WELWYN HATFIELD COUNCIL – DEVELOPMENT CONTROL
DELEGATED REPORT

APPLICATION No:	W6/2008/757/EM
------------------------	-----------------------

DESCRIPTION OF PROPOSAL: It is proposed to convert the existing garage into habitable accommodation. The proposed development would involve the bricking up of the existing garage door and instatement of windows.

PROPOSED ELEVATION
WITH GARAGE DOOR
REMOVED AND
BALCONY / WINDOW
TO MATCH EXISTING

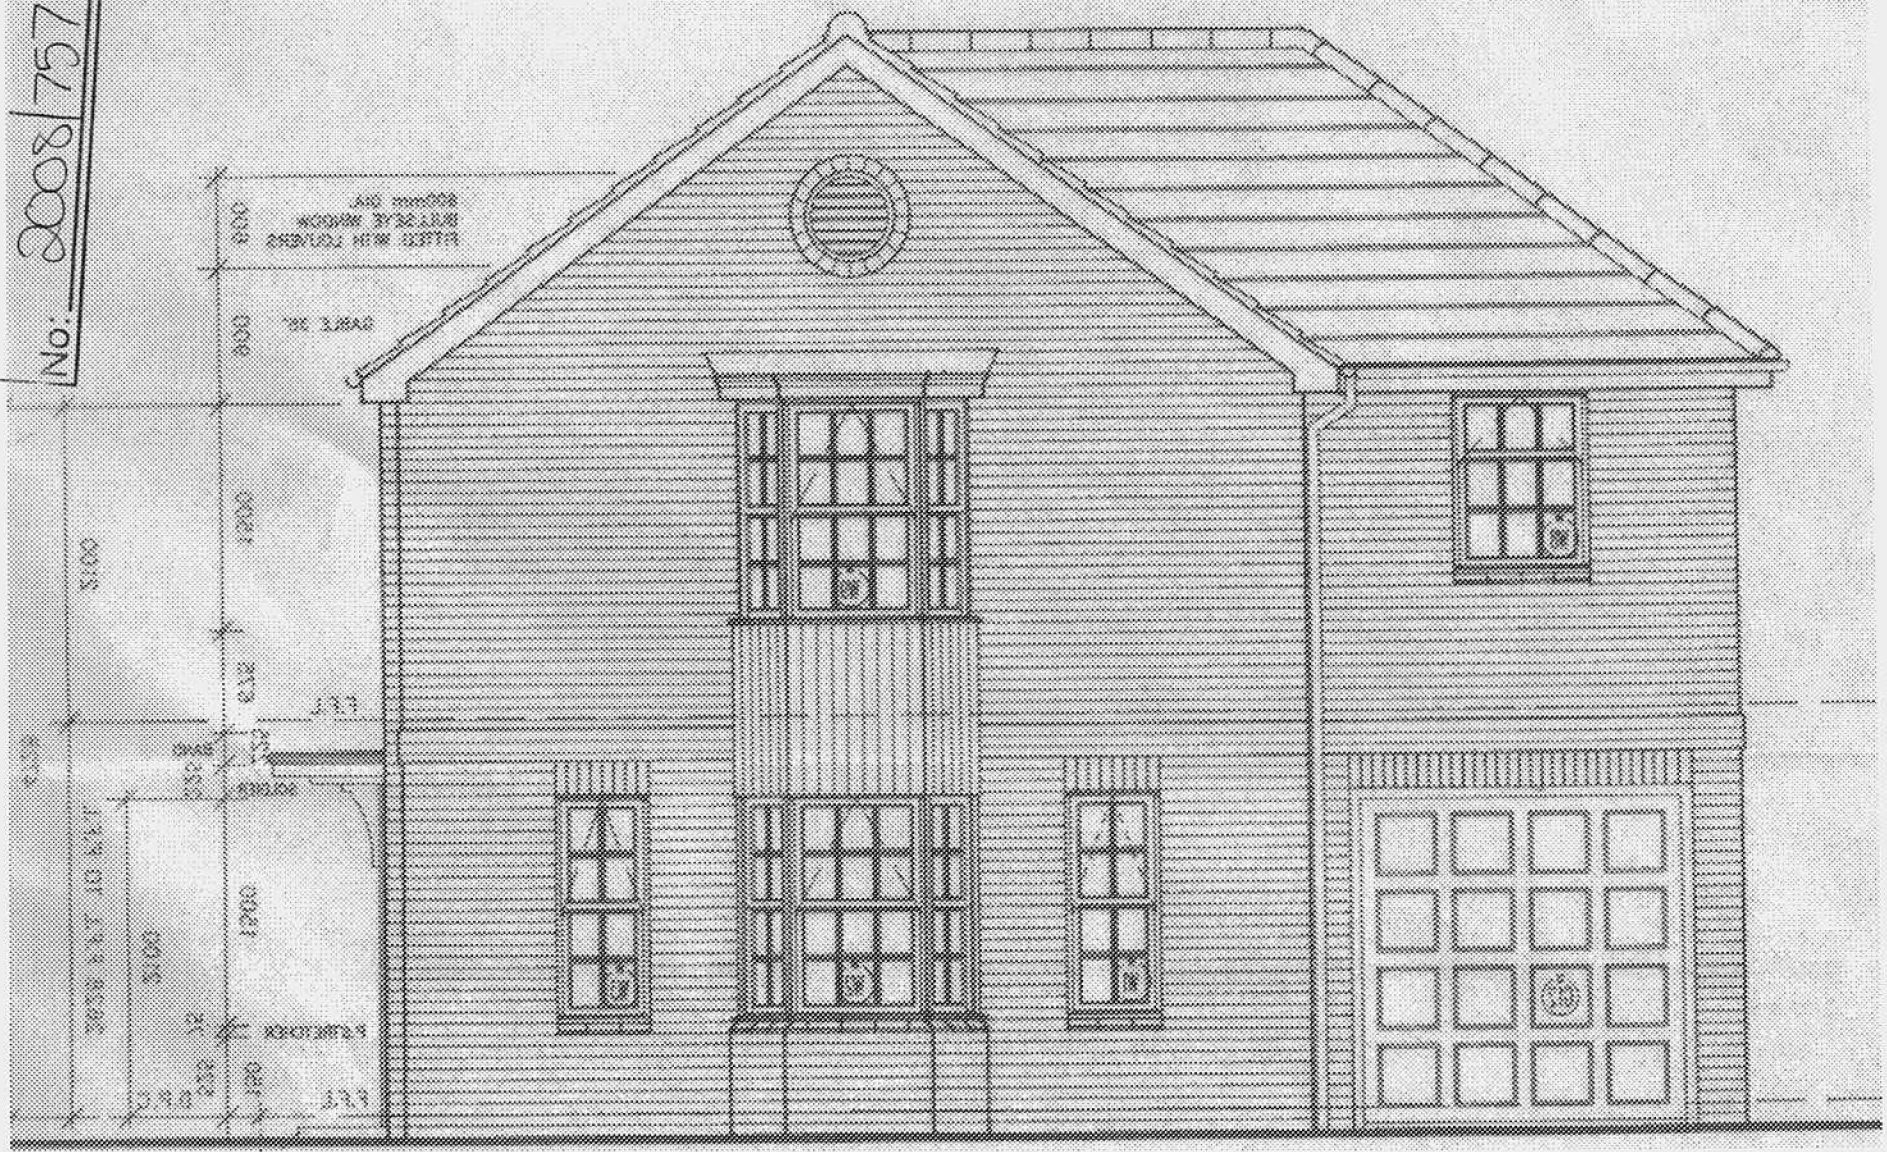
In terms of the impact of the proposal on the character and appearance of the dwelling, it is considered that the proposed development would appropriately feature materials and fenestration to match the existing dwelling. It is also considered that the proposed size and positioning of the fenestration would be positioned to maintain the symmetry that exists in the positioning and size of the existing fenestration.

Turning to the impact of the proposal on the character and appearance of the surrounding area, it is considered that whilst there are similar garages on properties in the surrounding area the replacement of the garage door with windows would not form a dominant addition to the frontage of the street scene and would be partially

obscured from view by hedging that is located on the property line of the site. It is therefore considered that the proposal would sufficiently maintain the character and appearance of the property and surrounding area.
